15/04/2020

**University of Newcastle STEMM Building (SSD-9832)
Response to Submissions**

ATTACHMENT 1

- LEGEND
- EXISTING TREES (SURVEYED BY ARBOR SAFE REPORT)
714 TREES
 - 138 CATEGORY A RETENTION VALUE TREES
(ARBOR SAFE REPORT)
 - TREE PROTECTION ZONE
 - EXTENT OF MAIN WORKS
 - 2061 TREE NUMBER

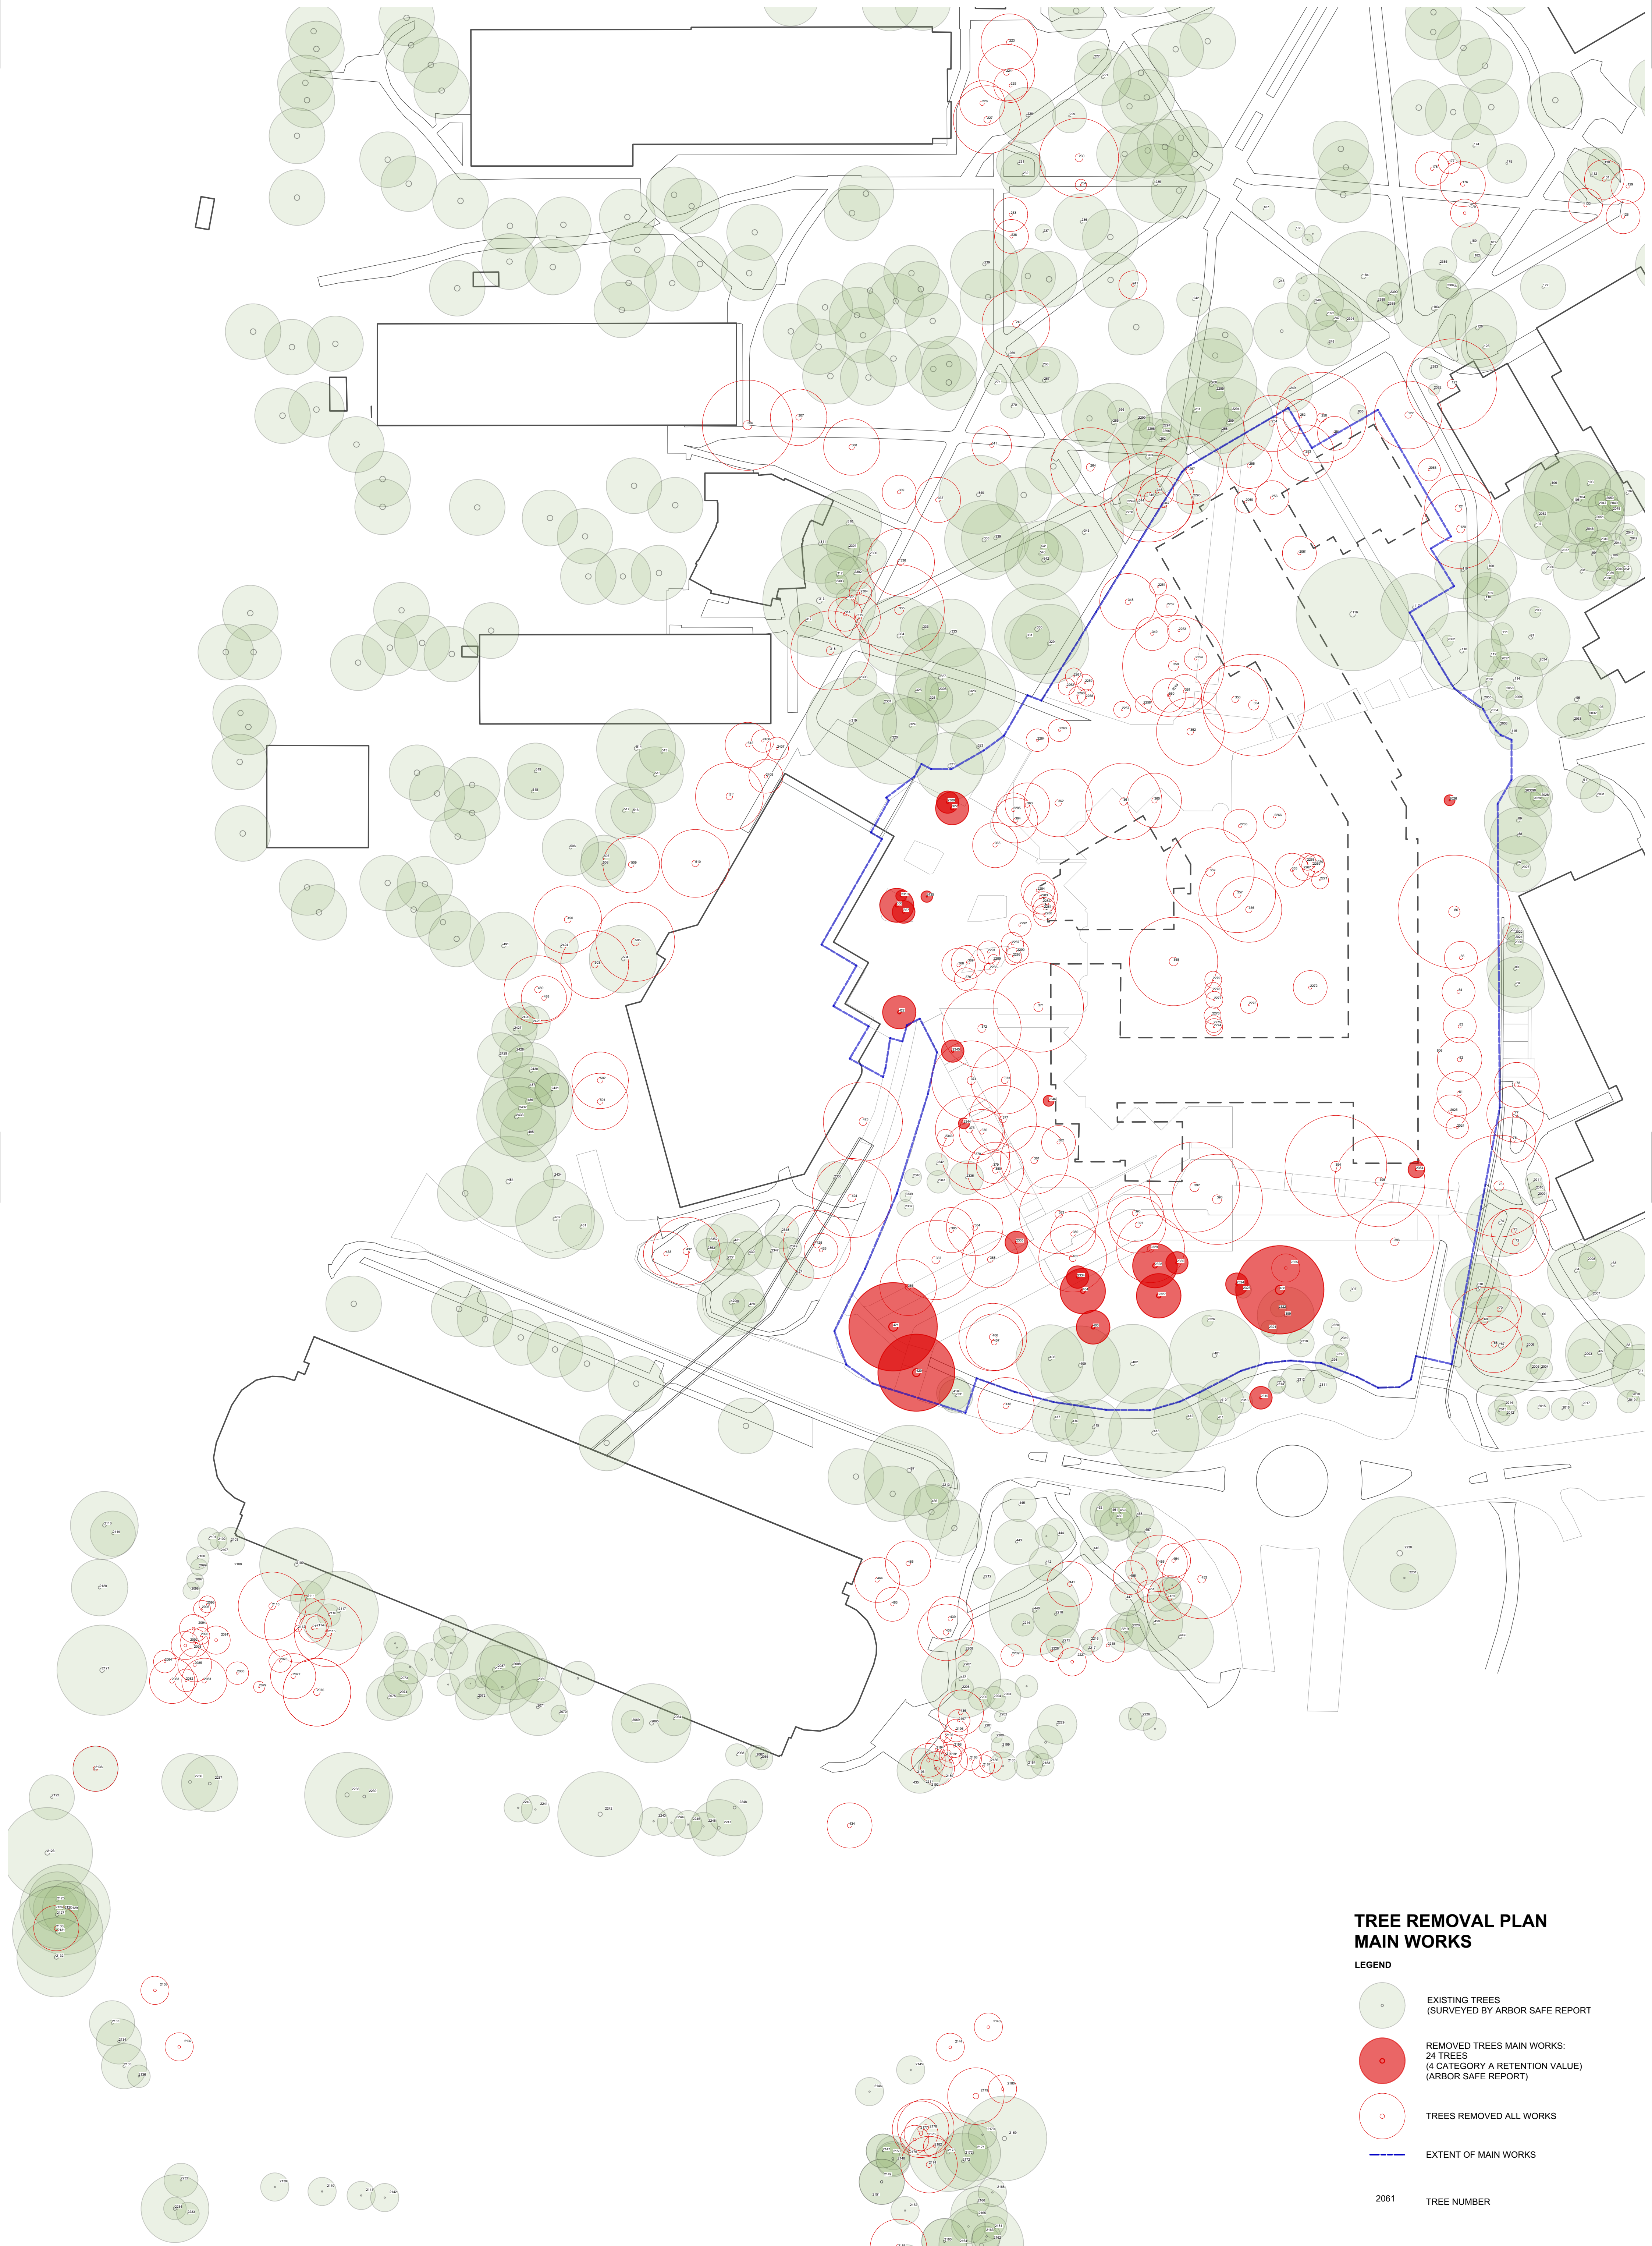
- provide Appendix D of the BDAR (Biodiversity Credit report).
- provide clarification of the number and location of existing trees and those being proposed for removal as the tree plan submitted (Appendix L pg. 8) does not match documentation presented to the State Design Review Panel.
